**2-60 Cumberland Street, the Rocks**  
Response to City of Sydney comments

This letter seeks to provide a response to the submission received from the City of Sydney on 17 May 2021. It complements the Response to Submissions submitted to DPIE on the 18 March 2021, and the further Response to Submissions submitted to DPIE on the 7 May 2021.

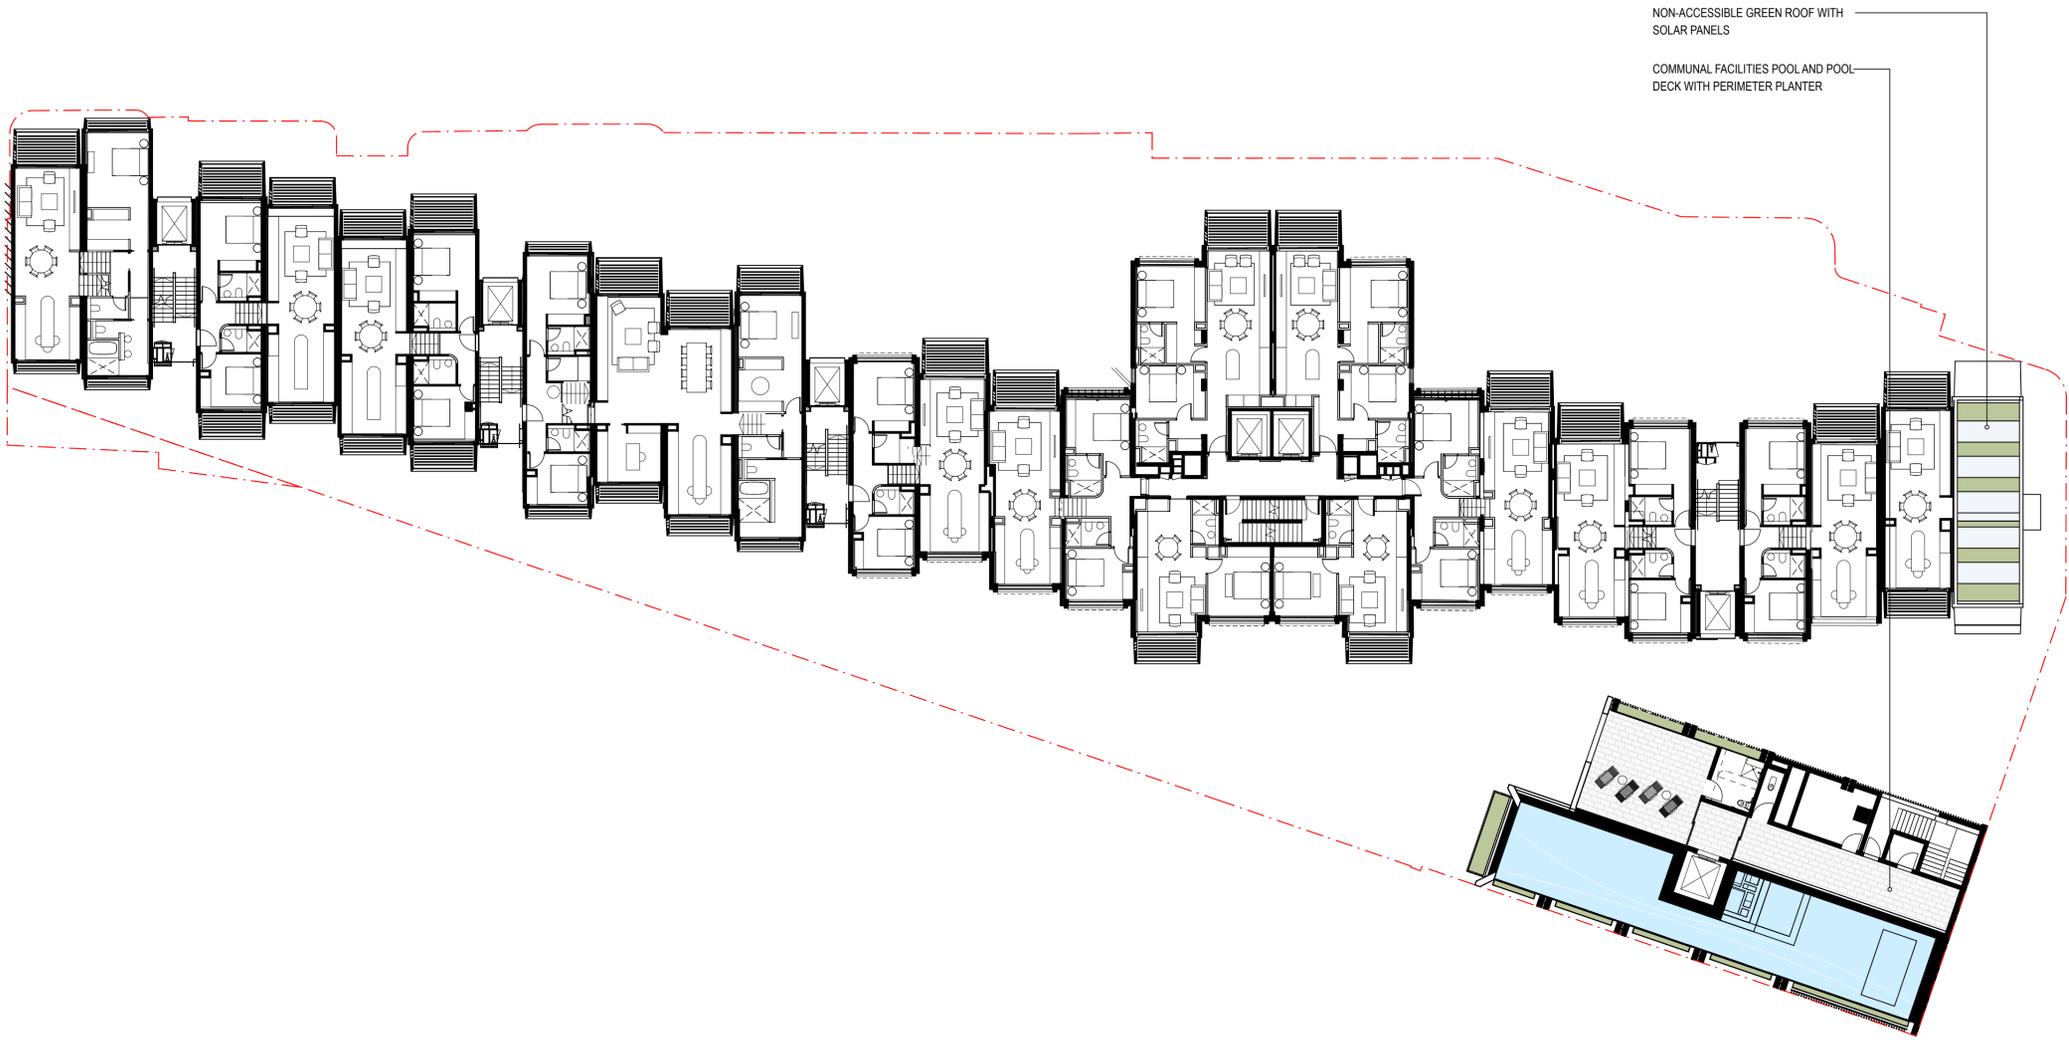
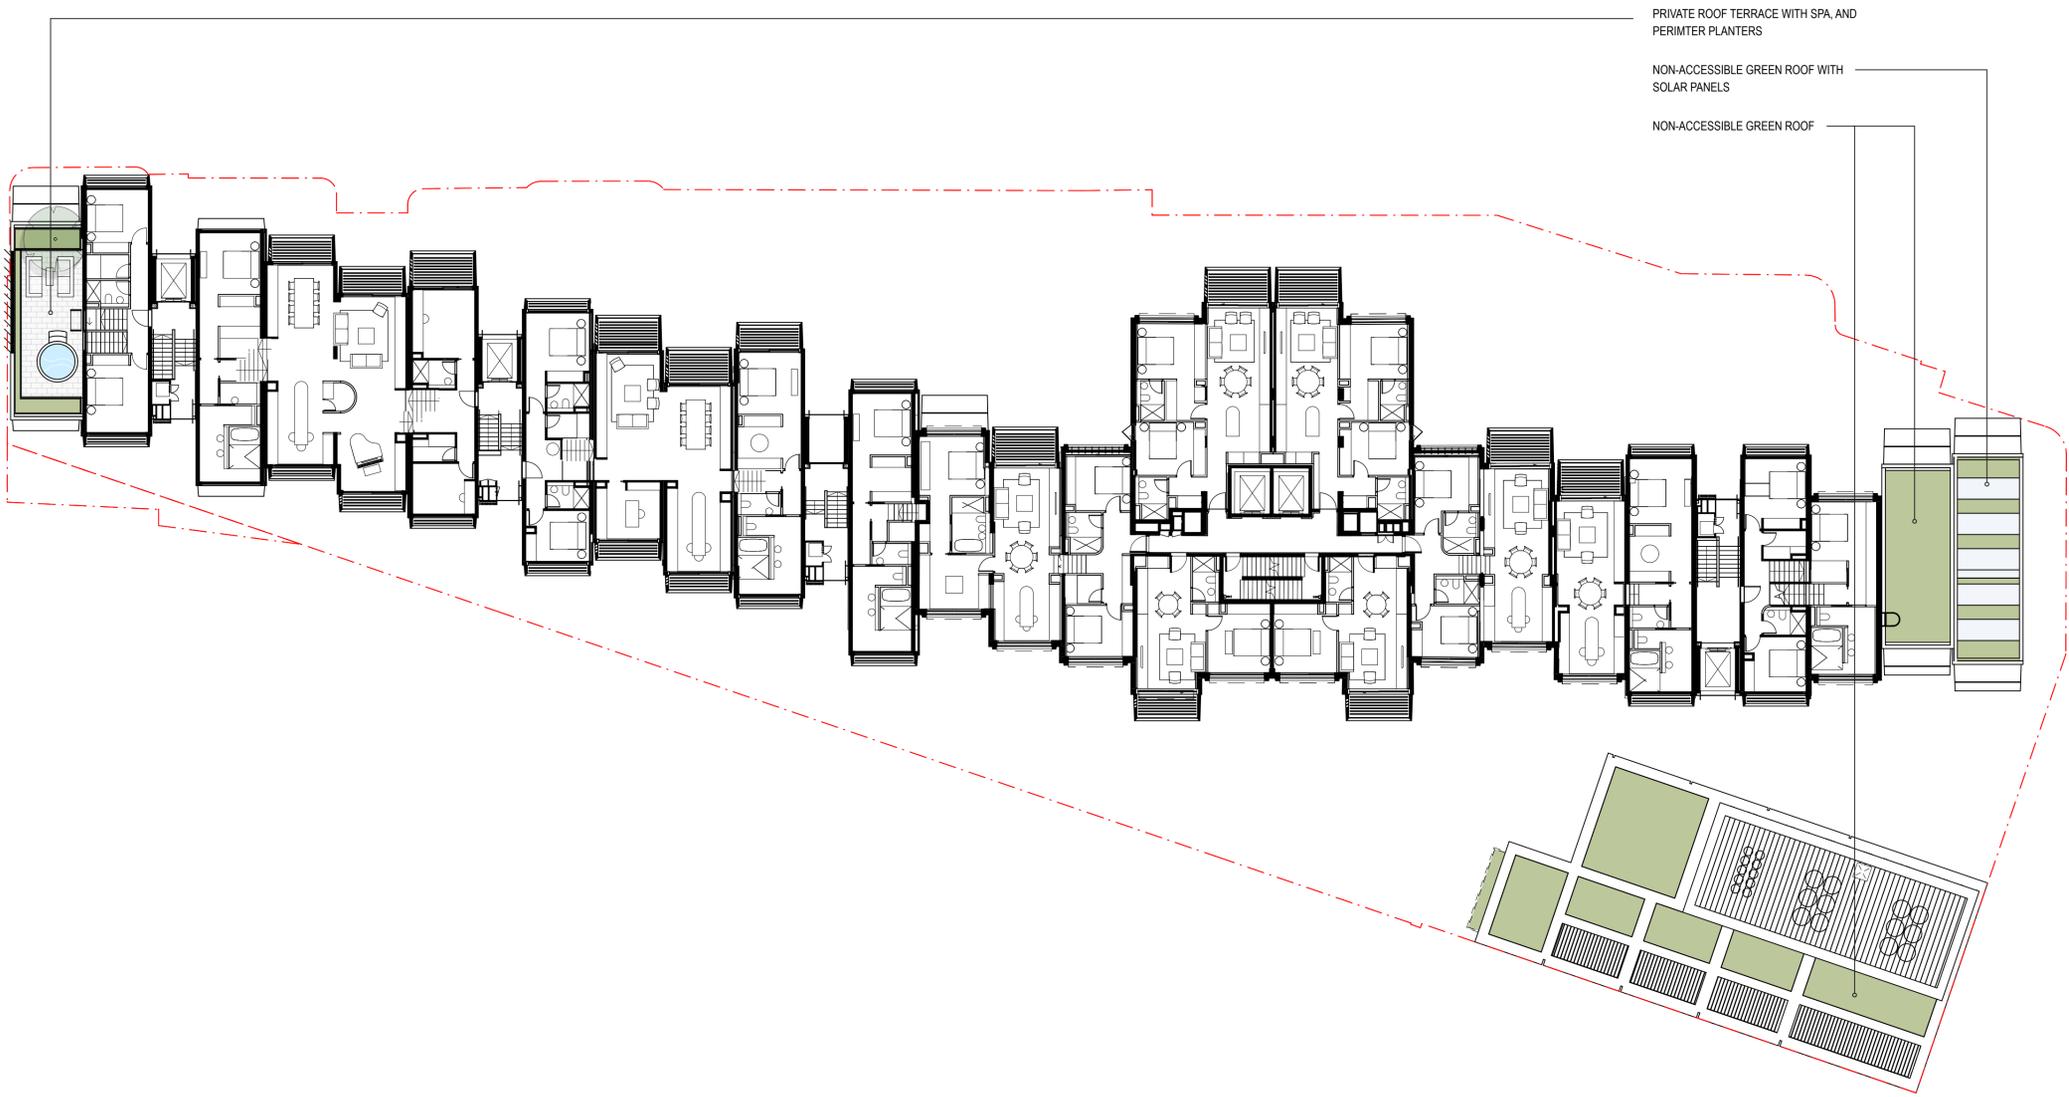
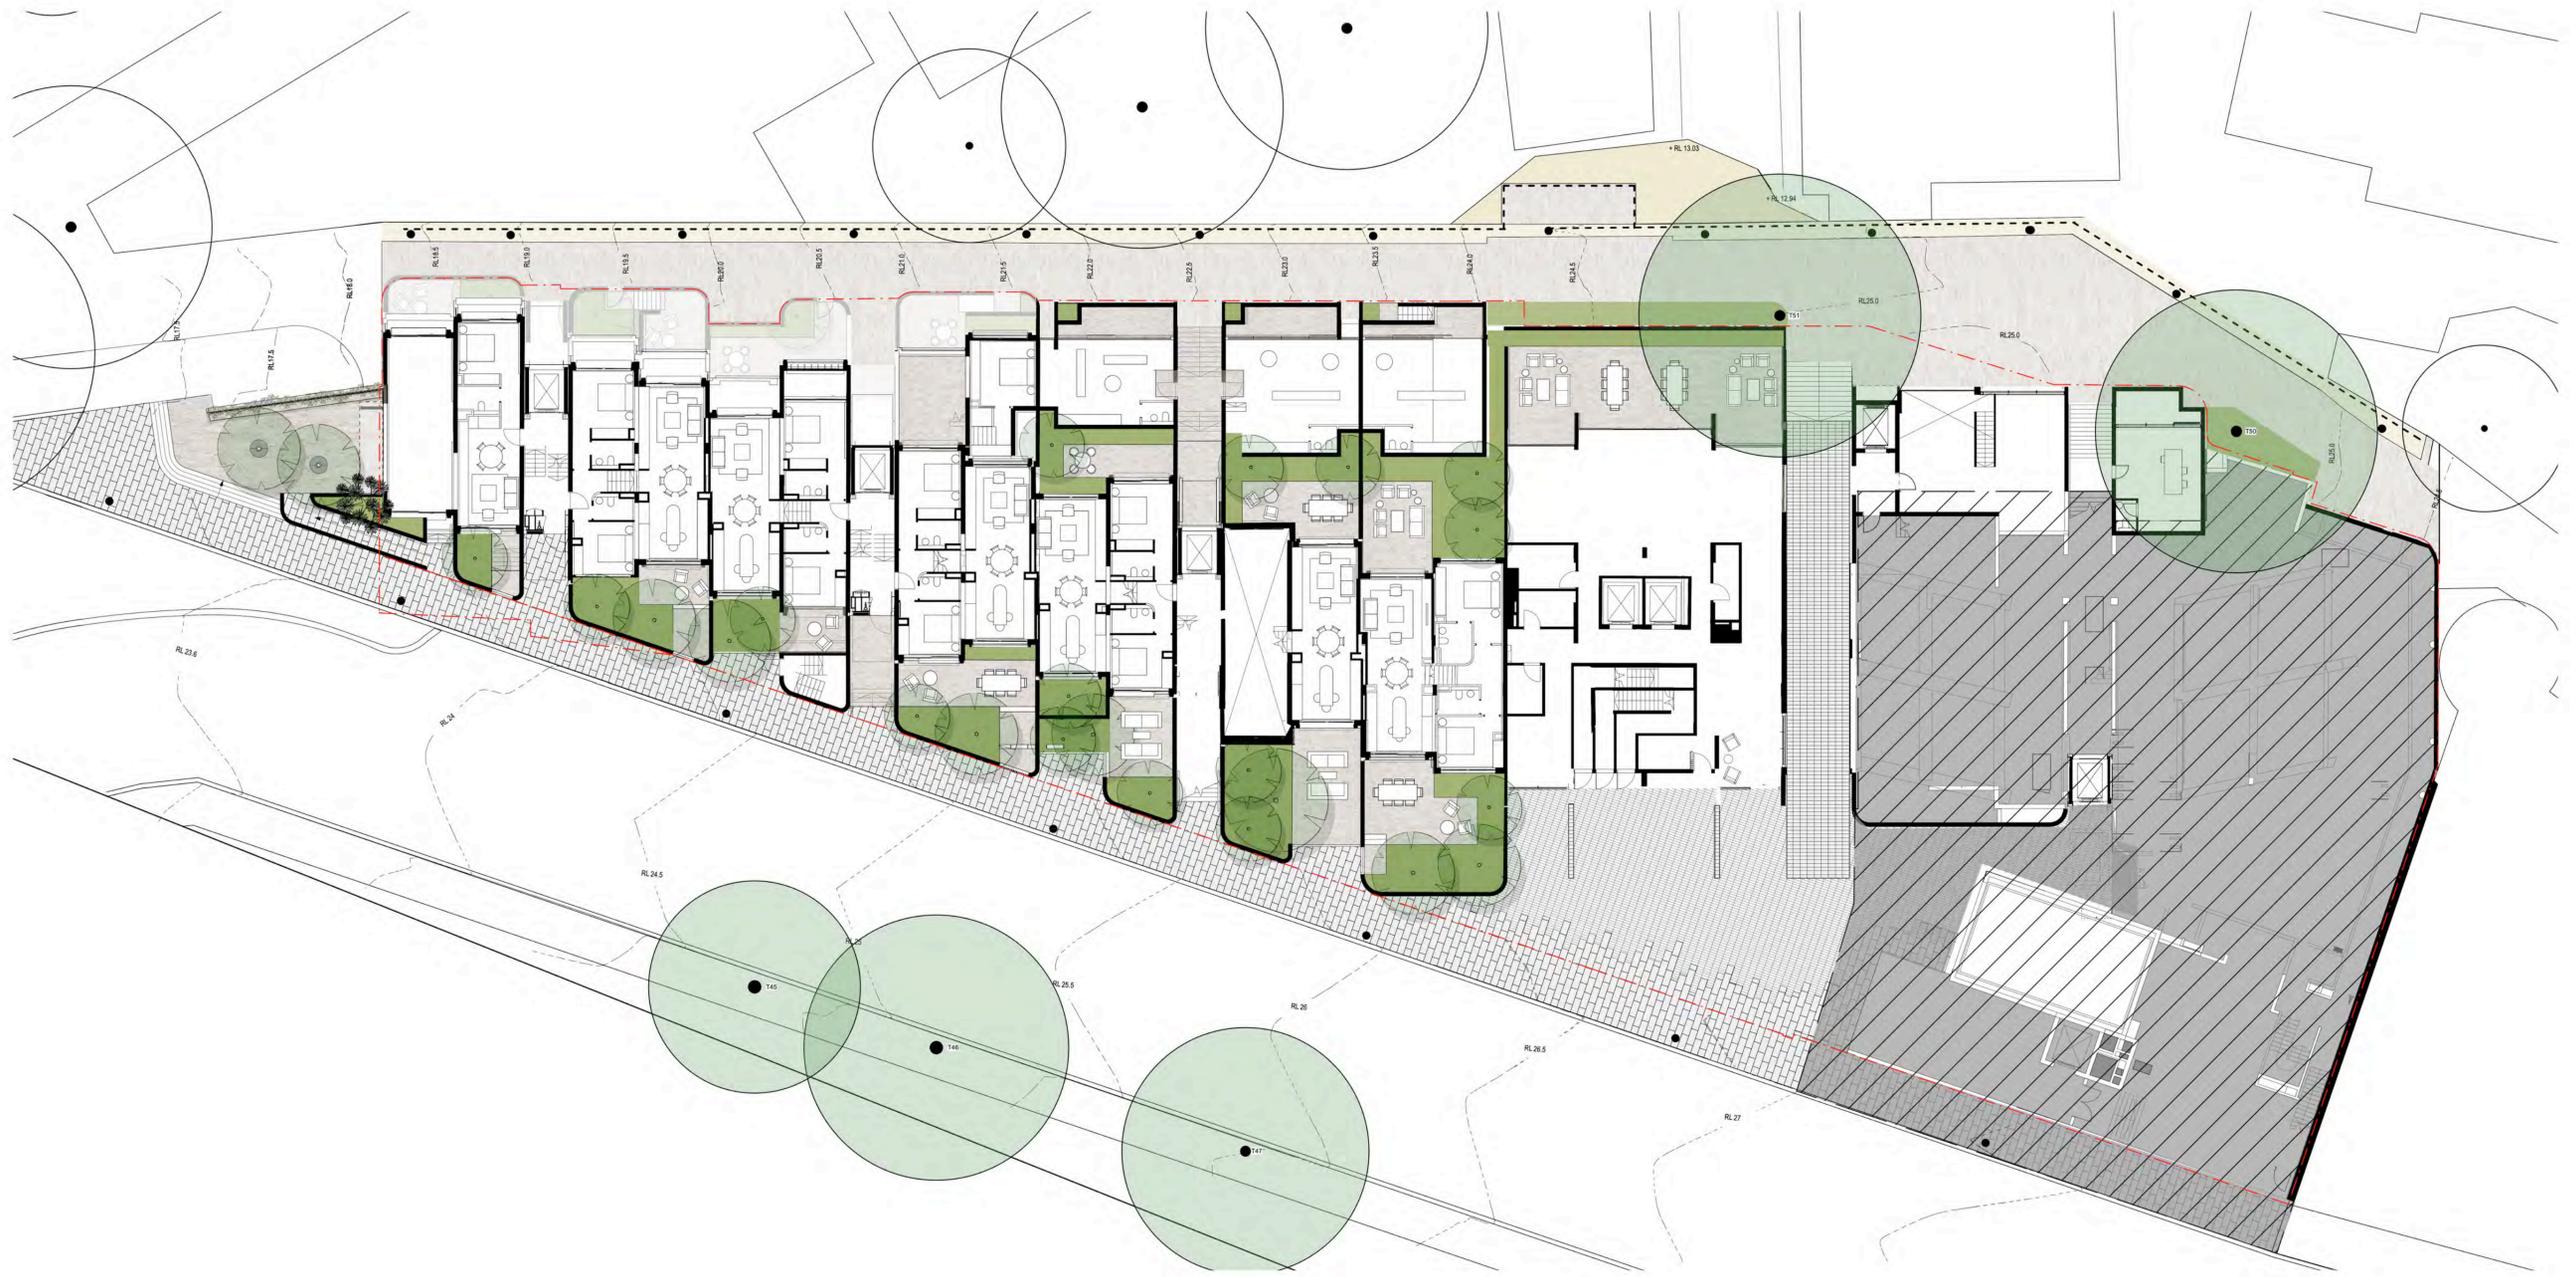
<p>The tree within the raised planter next to the cafe is unlikely to reach maturity due to limited soil volume. This planter must be amended so it provides soil volumes in accordance with medium trees under the Sydney Landscape Code.</p>	<p>This tree has been substituted with a grove of <i>Livistona australis</i> (Cabbage Tree Palm) with the planter size amended to meet soil requirements.</p>
<p>The proposed Frangipani trees are a slow growing species and are unlikely to reach a size that would allow the site to reach the canopy cover requirements within ten years. This tree species must be amended to a more appropriate tree. The use of Chinese Elm, Weeping Lillypilly, Water Gum and Crepe Myrtle is supported.</p>	<p>Frangipani's have been substituted with Crepe Myrtles.</p>
<p>It is understood that the proposed street tree planting will be subject to approval from Place Management NSW. It is recommended that the street tree planting, similar to the proposed installation of City specified smart poles, should be undertaken in accordance</p>	<p>This is supported and can be addressed as a condition of consent.</p>
